Martin Nugent
01254 828060
D3/12/0965

Drafted 28 November 2012

**Planning Application, Ribble Valley District
3/12/0965 74 Salthill Road, Clitheroe**

Sheet  
Proposed Site Plan

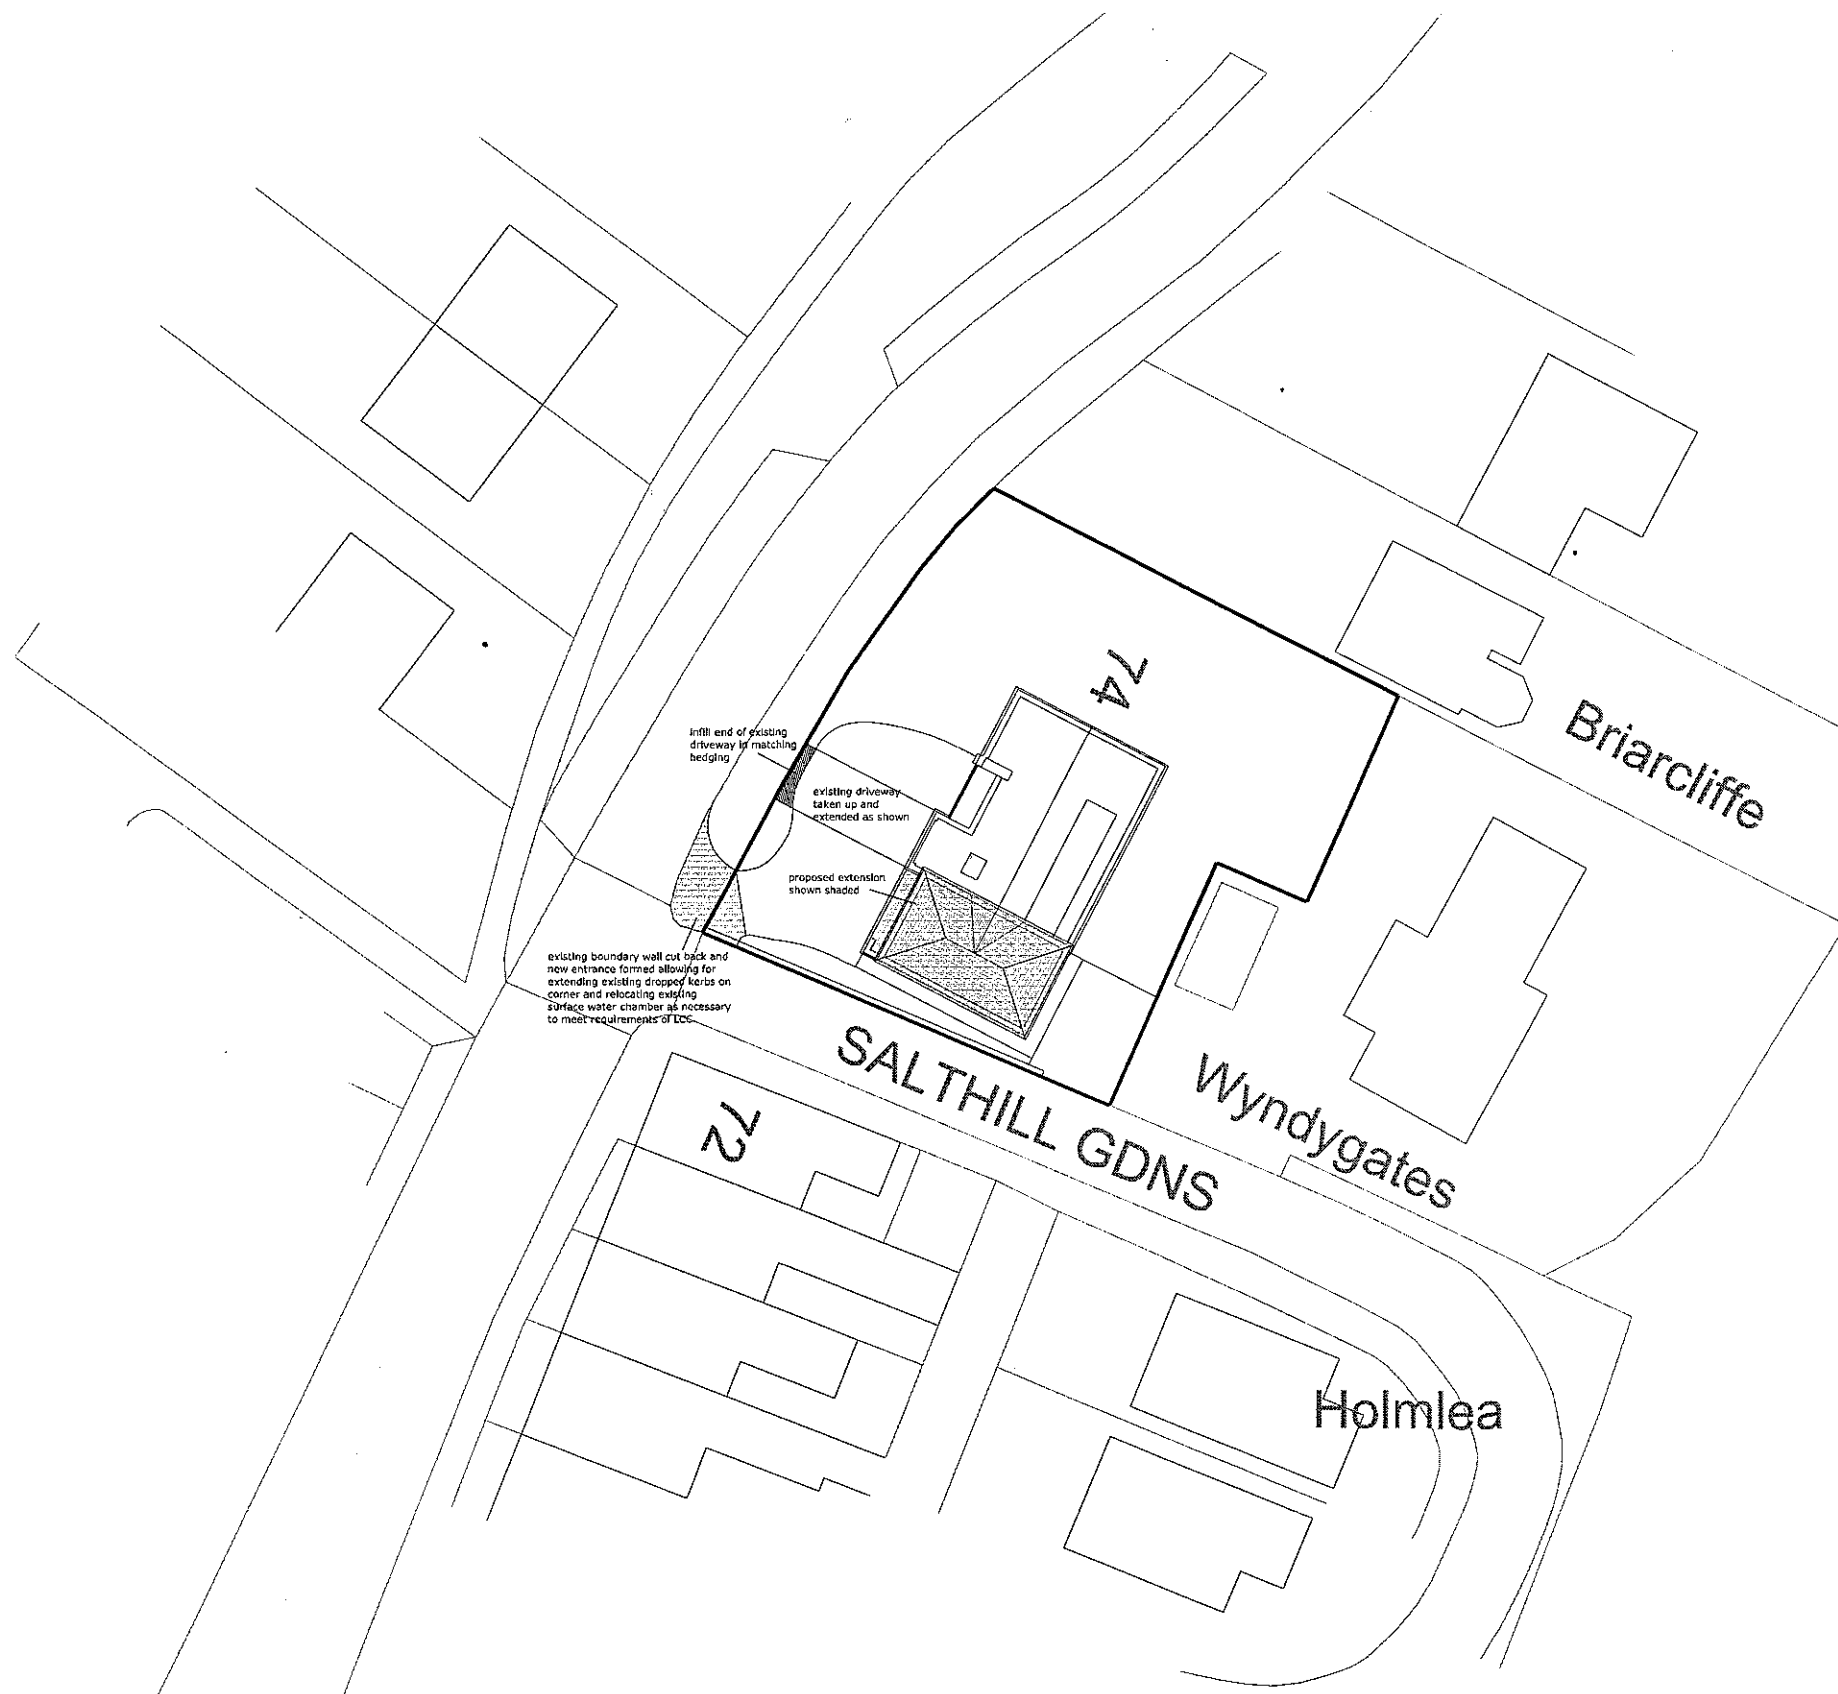
However, the proposed vehicular access aims to utilise, in part, a drop kerb introduced for the benefit of pedestrians. In order that pedestrians are not discouraged from continuing to cross Salthill Gardens at this safe location.

The existing drop kerbs do not run for the full length of the access and, as a result, that access to the proposed driveway will be restricted unless vehicles run over the adjacent full height kerbs.

The service cover in the footway to the west of the driveway was vulnerable to over-running by private vehicles and will be relocated following discussions to agree a suitable new location.

However, both of the above points are addressed on the site plan, Drawing No.11/140/004 and can be resolved with the introduction of the access treatment as per the relevant drawing.

The extension of the driveway will require the provision of new drop kerbs and alterations to the footway. The construction and maintenance of these items must be completed in accordance with a scheme to be agreed by the Local Planning Authority in conjunction with the Highway Authority.
